Recommendation Report for Planning Permission for Works or Extension to a Dwelling

REF NO: AW/74/22/HH

LOCATION: Pennyfarthing
5 Kingsway
Aldwick
PO21 4DQ

PROPOSAL: Two storey rear extension. This application affects the character and appearance of the Craigwell House Conservation Area.

PROPOSED FIRST FLOOR PLAN

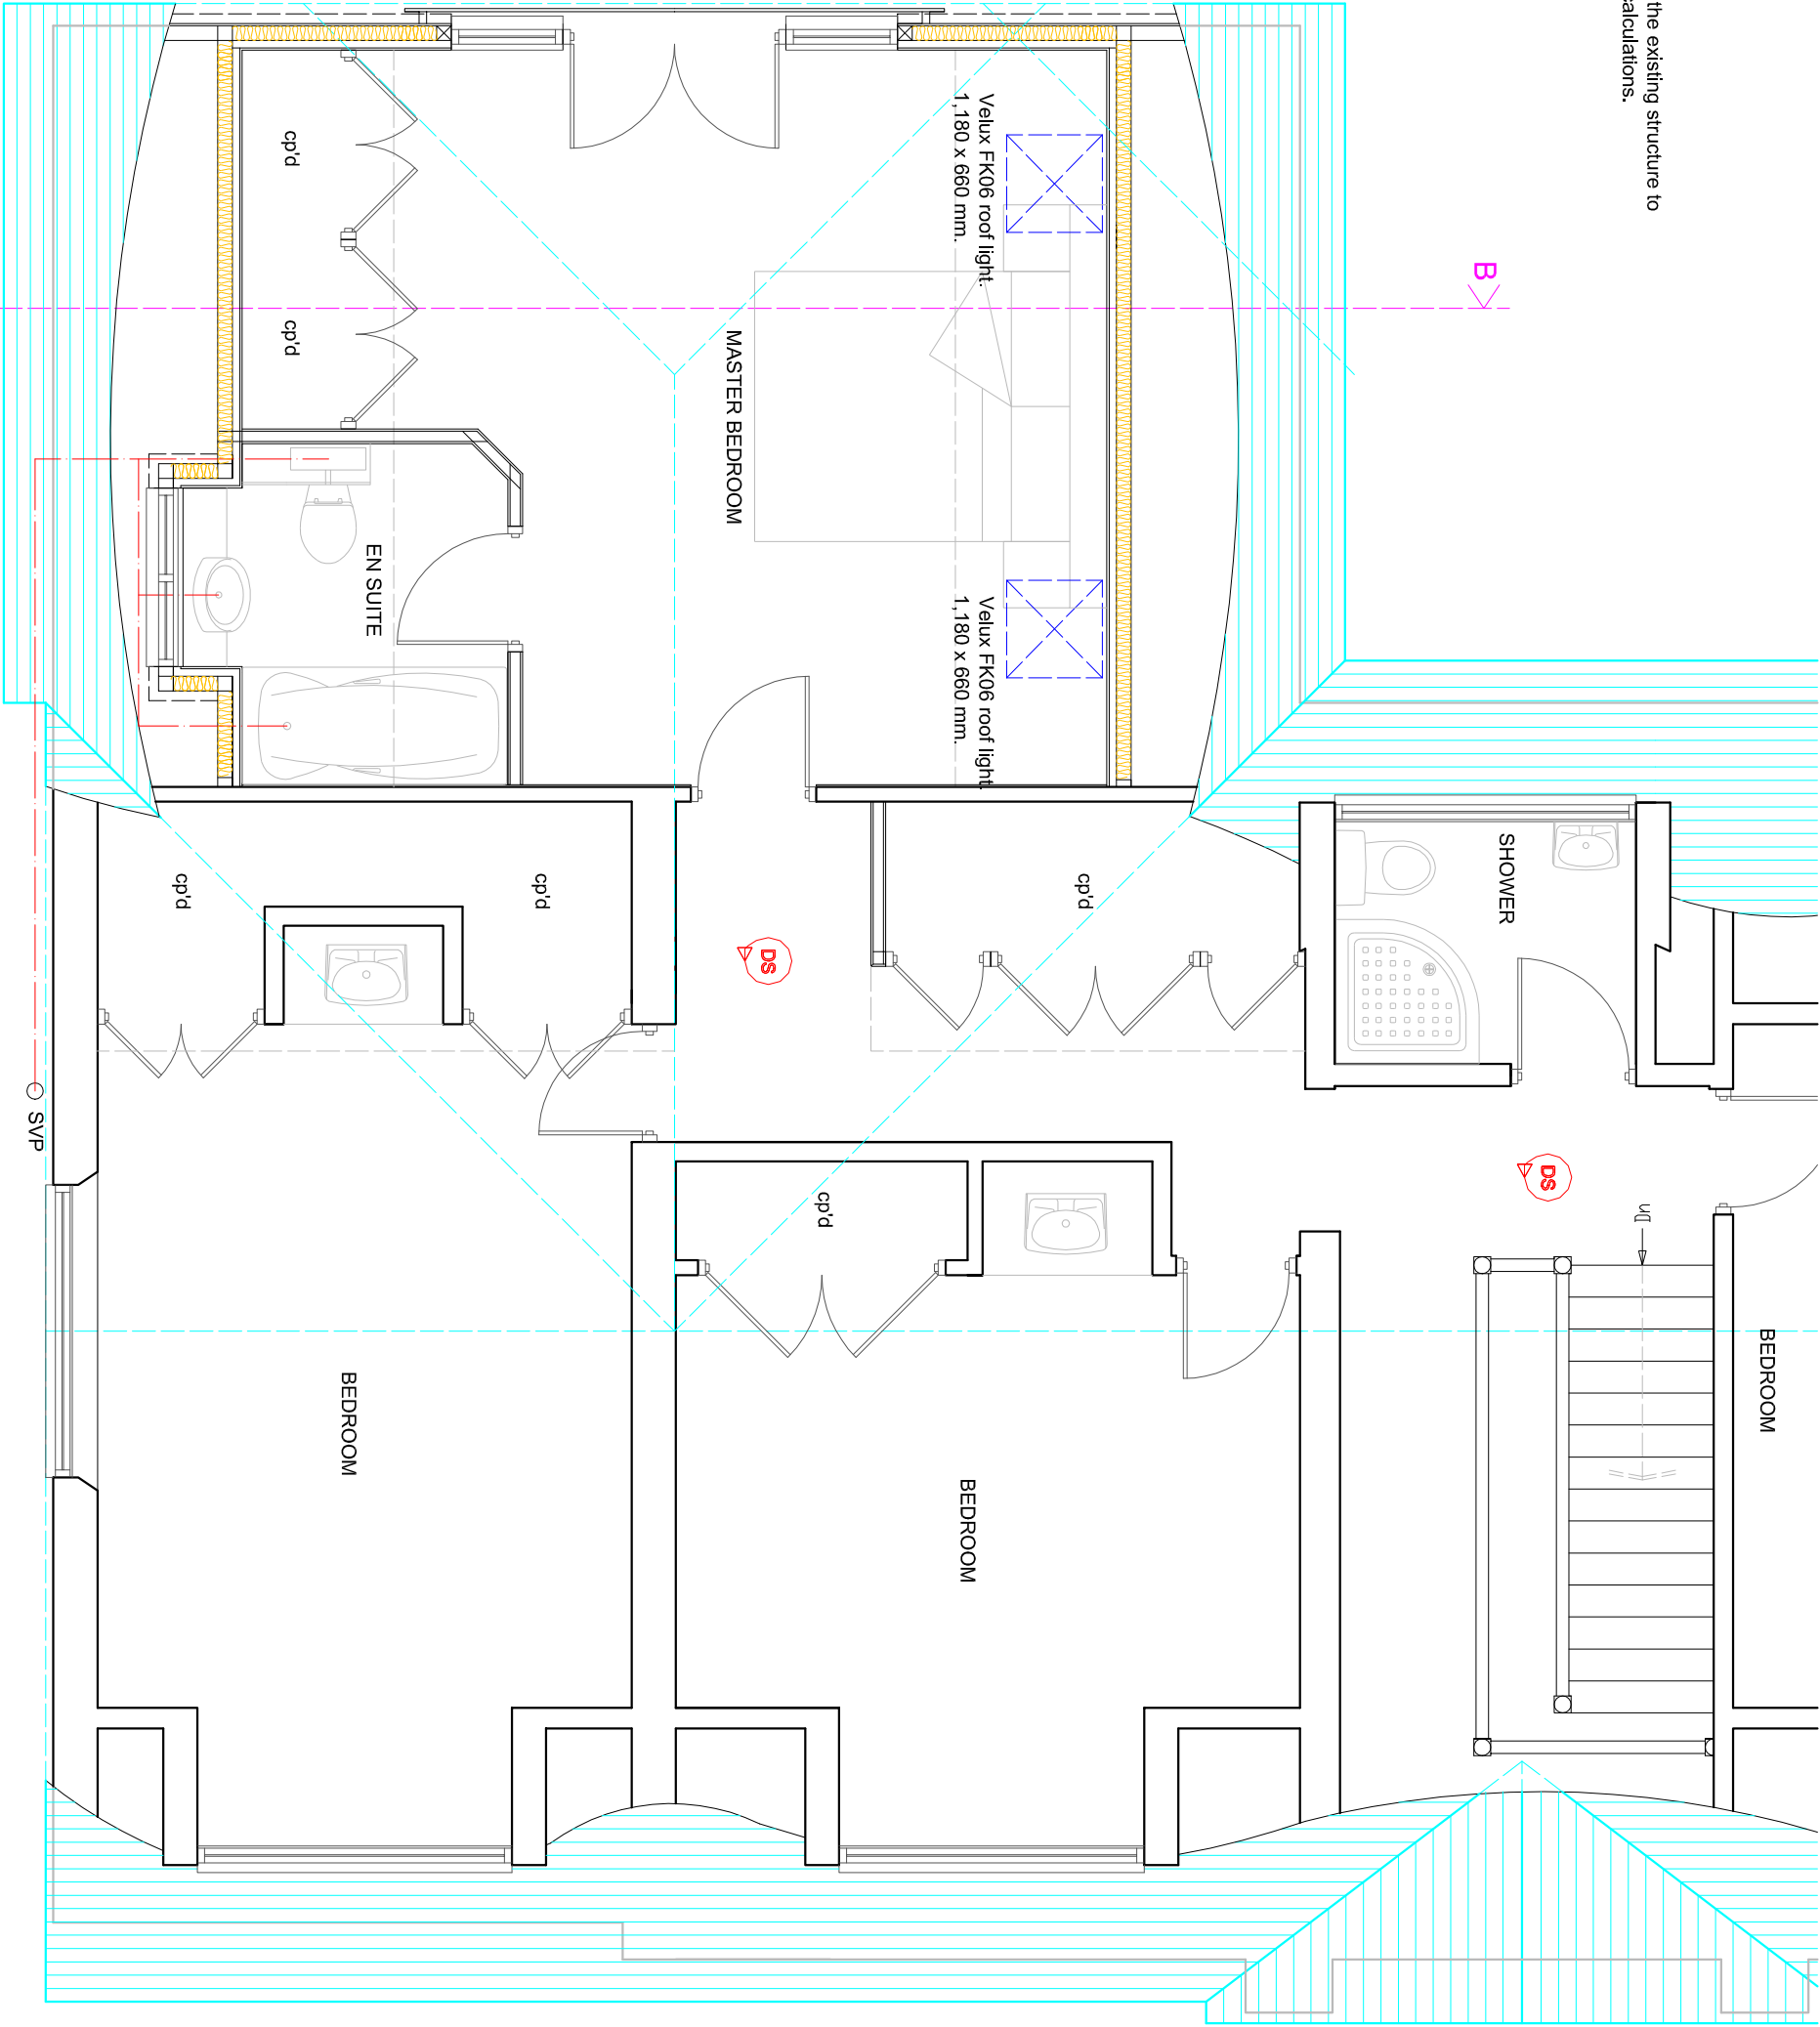
A dormer is proposed to the western side elevation of the extension. This has a depth of 1.2m, a width of 1.7m and a height of 2.3m. Whilst some distance from the boundary, it does have the potential for direct views over the garden of No.3 and it will be conditioned to remain obscured glazing, serving a bathroom.

- 3 The first floor window to the dormer on the western elevation of the building shall at all times be glazed with obscured glass and only openable at a high level, at least 1.7m above finished floor level.

PROPOSED GROUND FLOOR PLAN

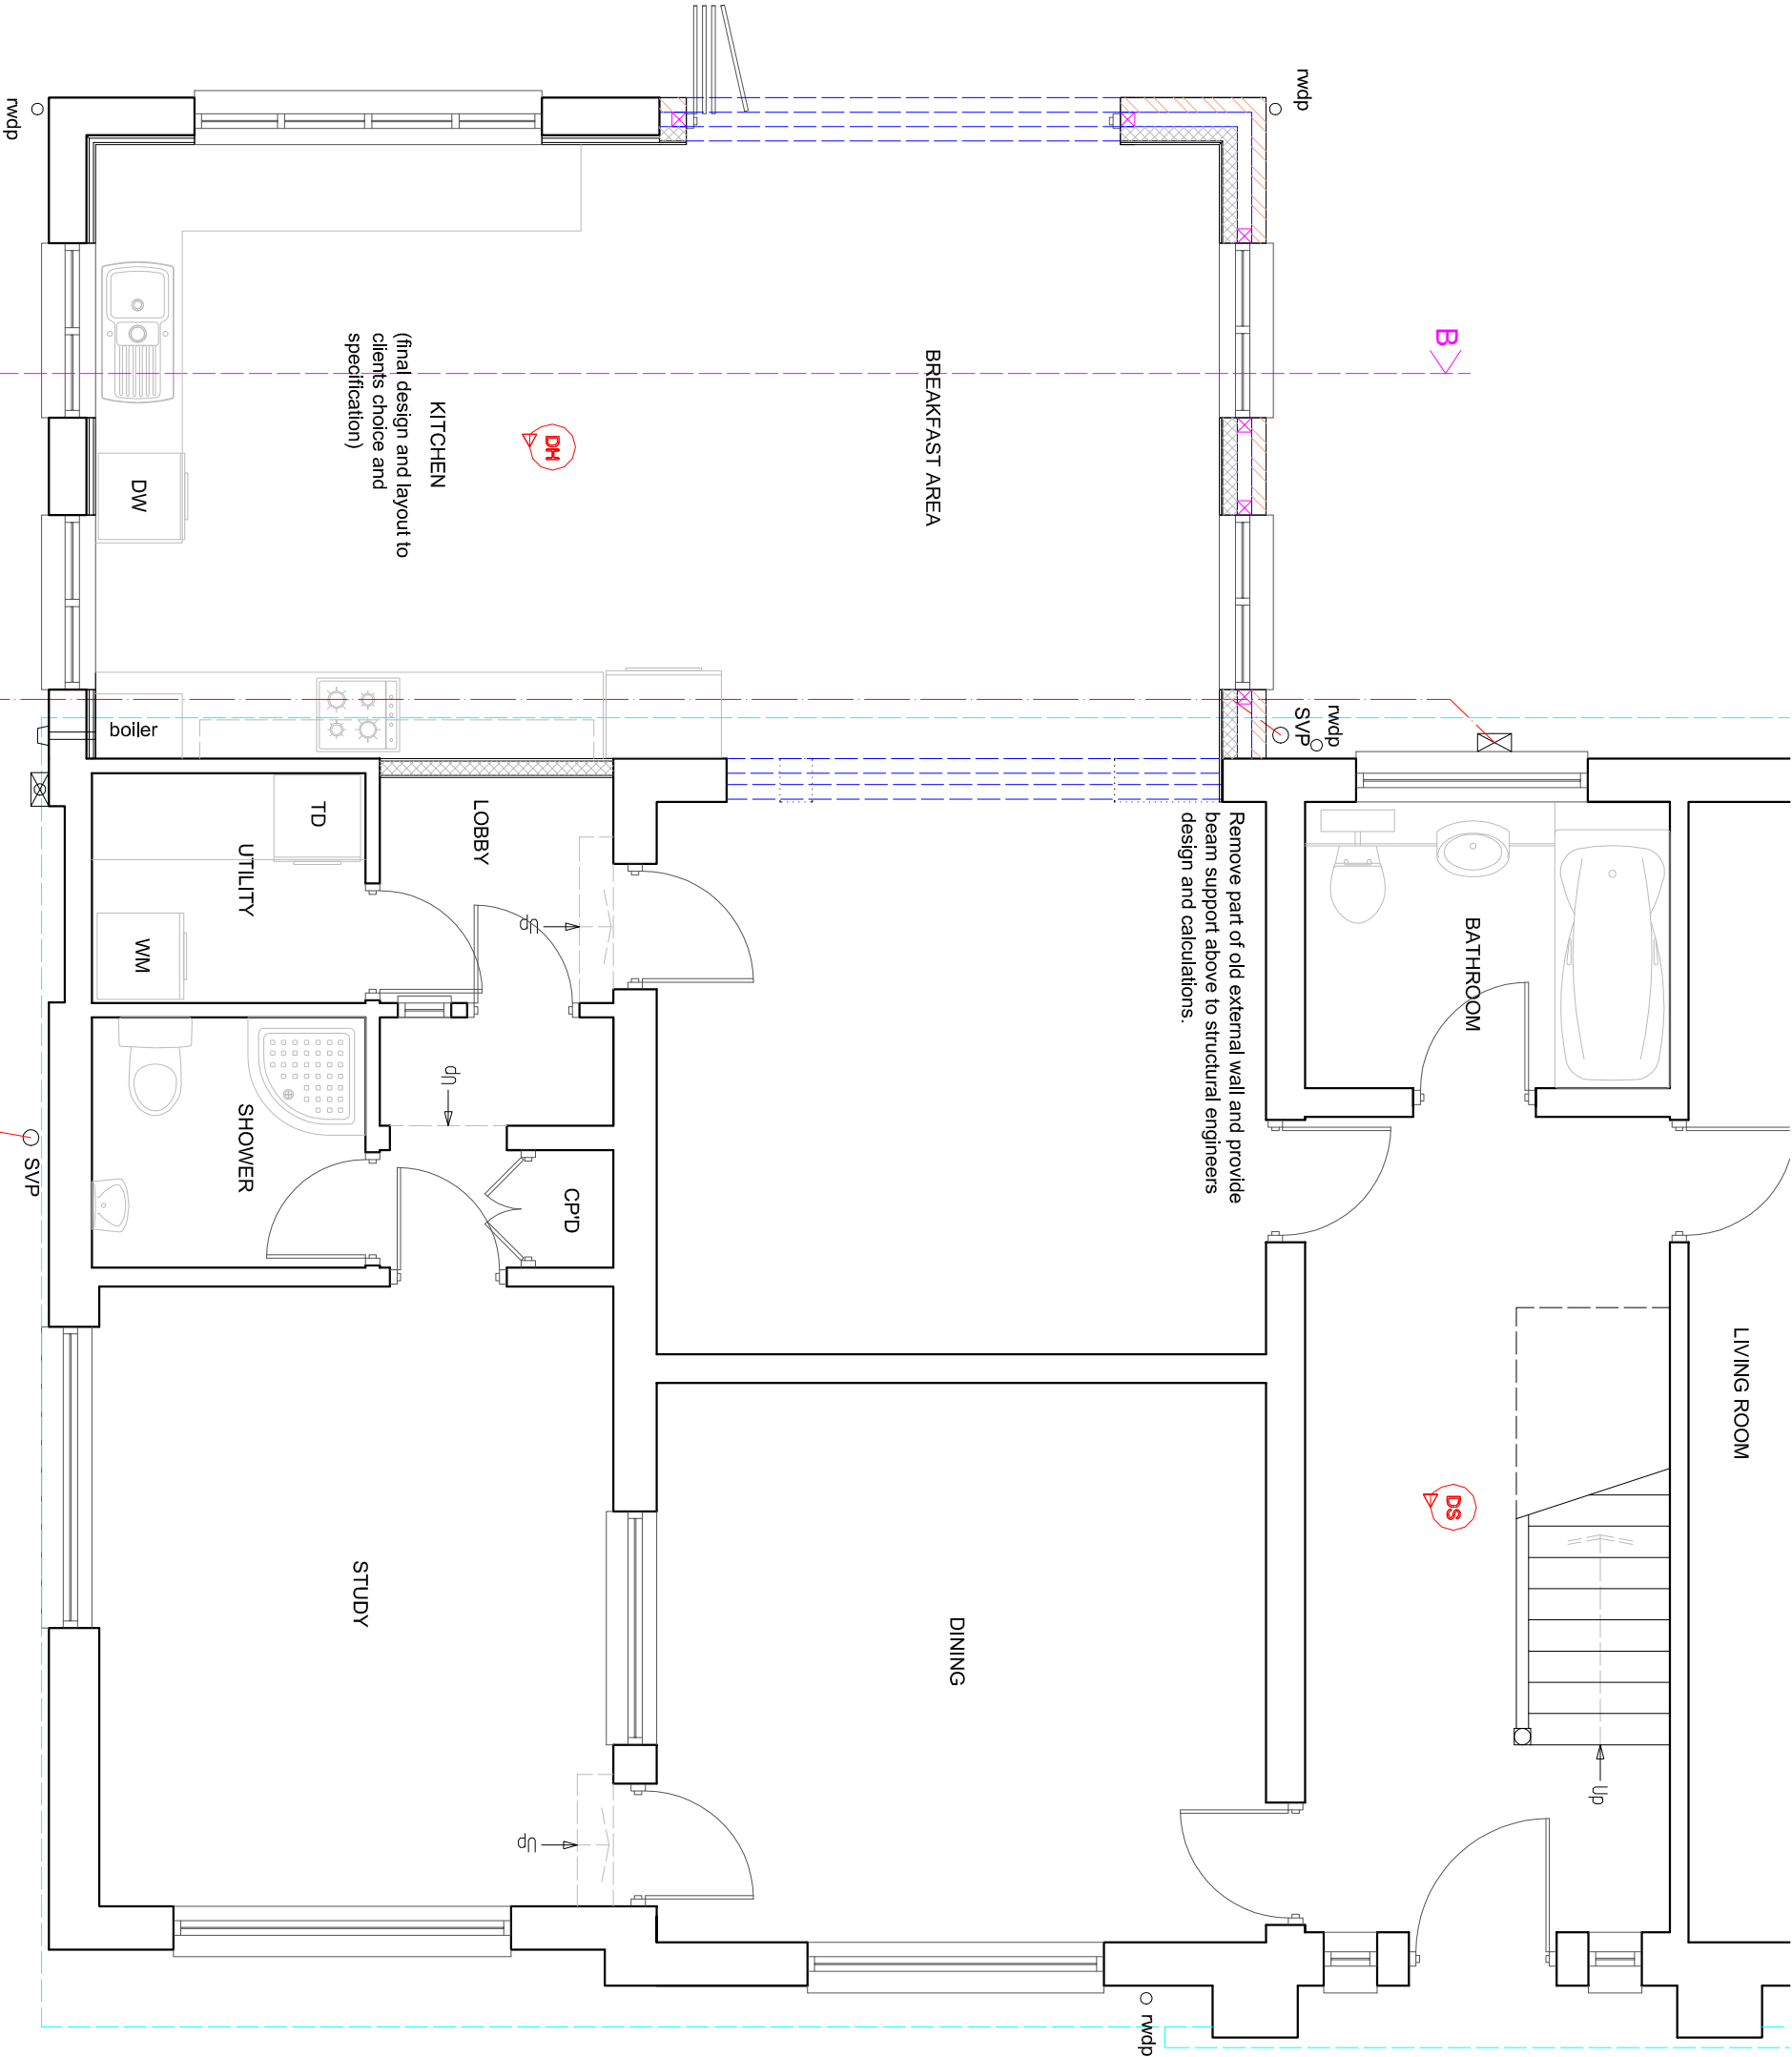
There is an existing conservatory and this will be replaced with a two storey extension. This extends to the same depth as existing at 4.5m although will increase in height.

The extension will have a depth of 4.5m and runs along approximately half of the rear elevation of the dwelling.

PROPOSED ELEVATIONS

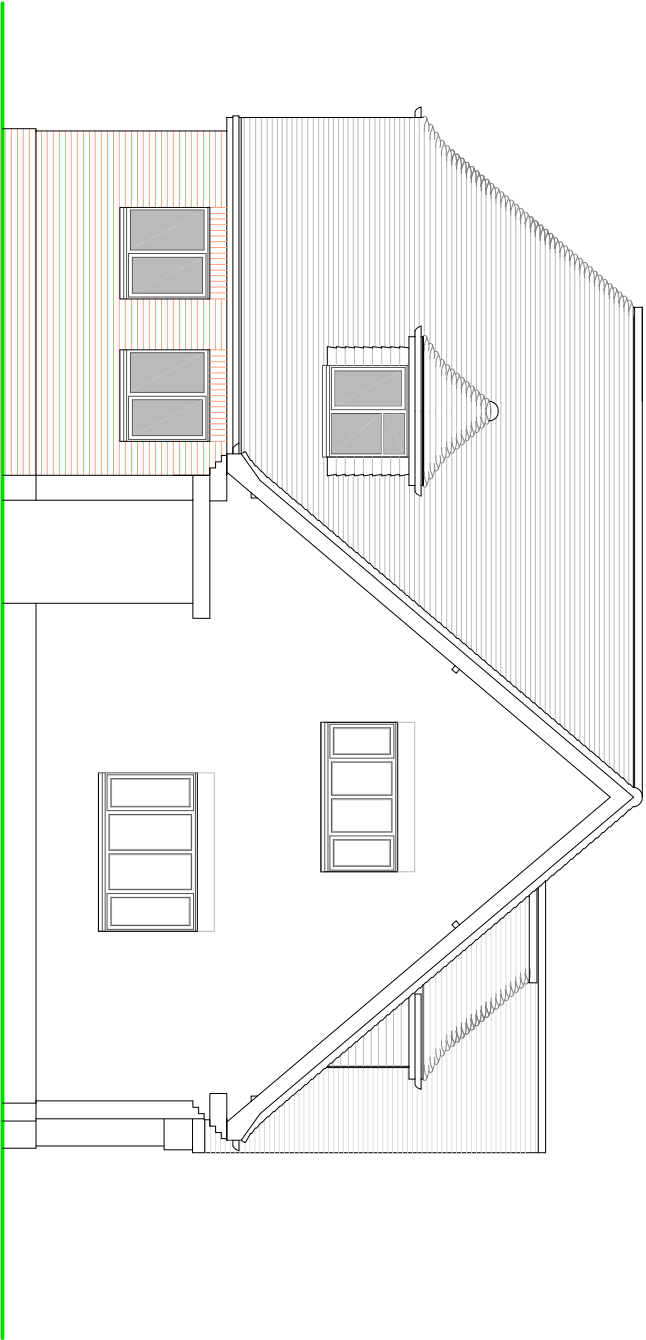
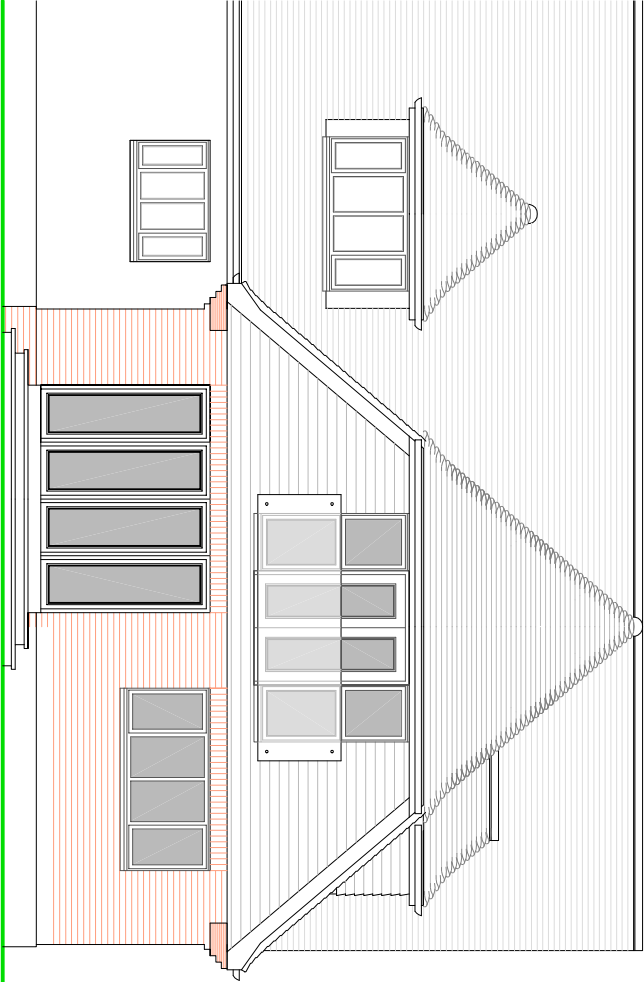
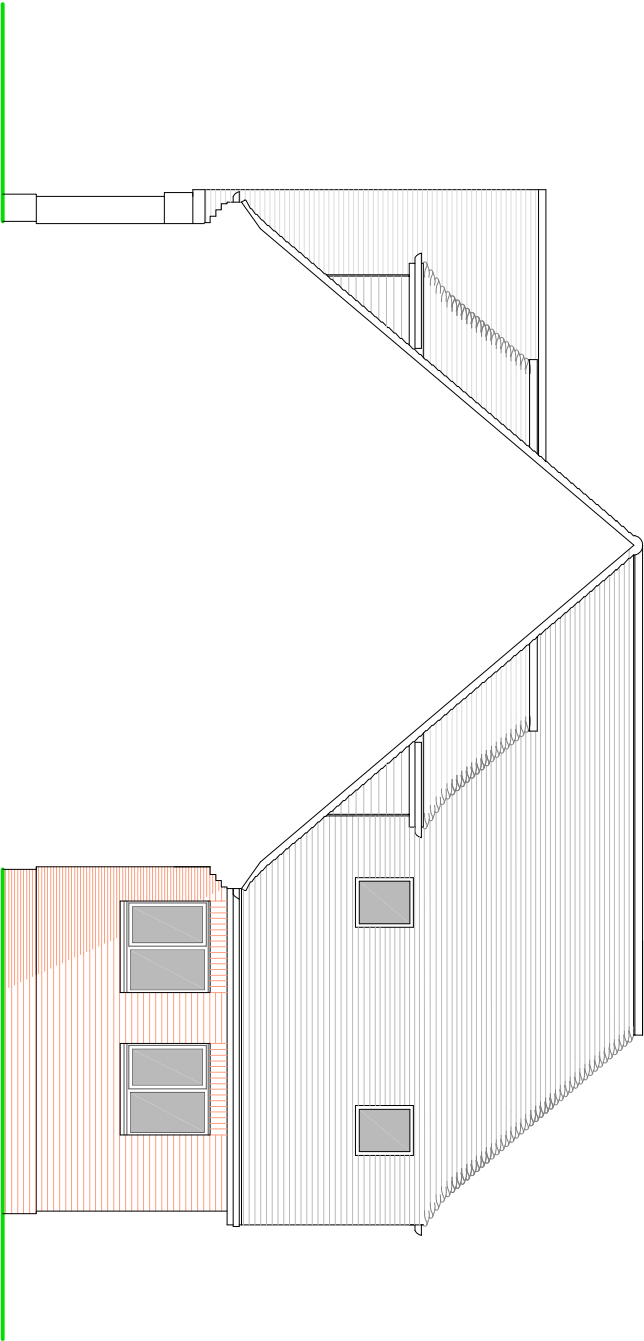
The extension will have a barn hip roof and extends from the ridge of the dwelling and therefore will add some bulk to the rear. The design and appearance of the extension is however well integrated with the host dwelling. A dormer is proposed to the western side, although this is minor in size.

There will be a rear facing juliet balcony to the first floor although this will not provide adverse

overlooking with no views direct into neighbouring properties. It will provide some views into neighbouring gardens although when looking at a 45 degree angle this is minimal. There will be two rooflights to the eastern side. This retains 24m to the boundary and will not result in adverse overlooking.
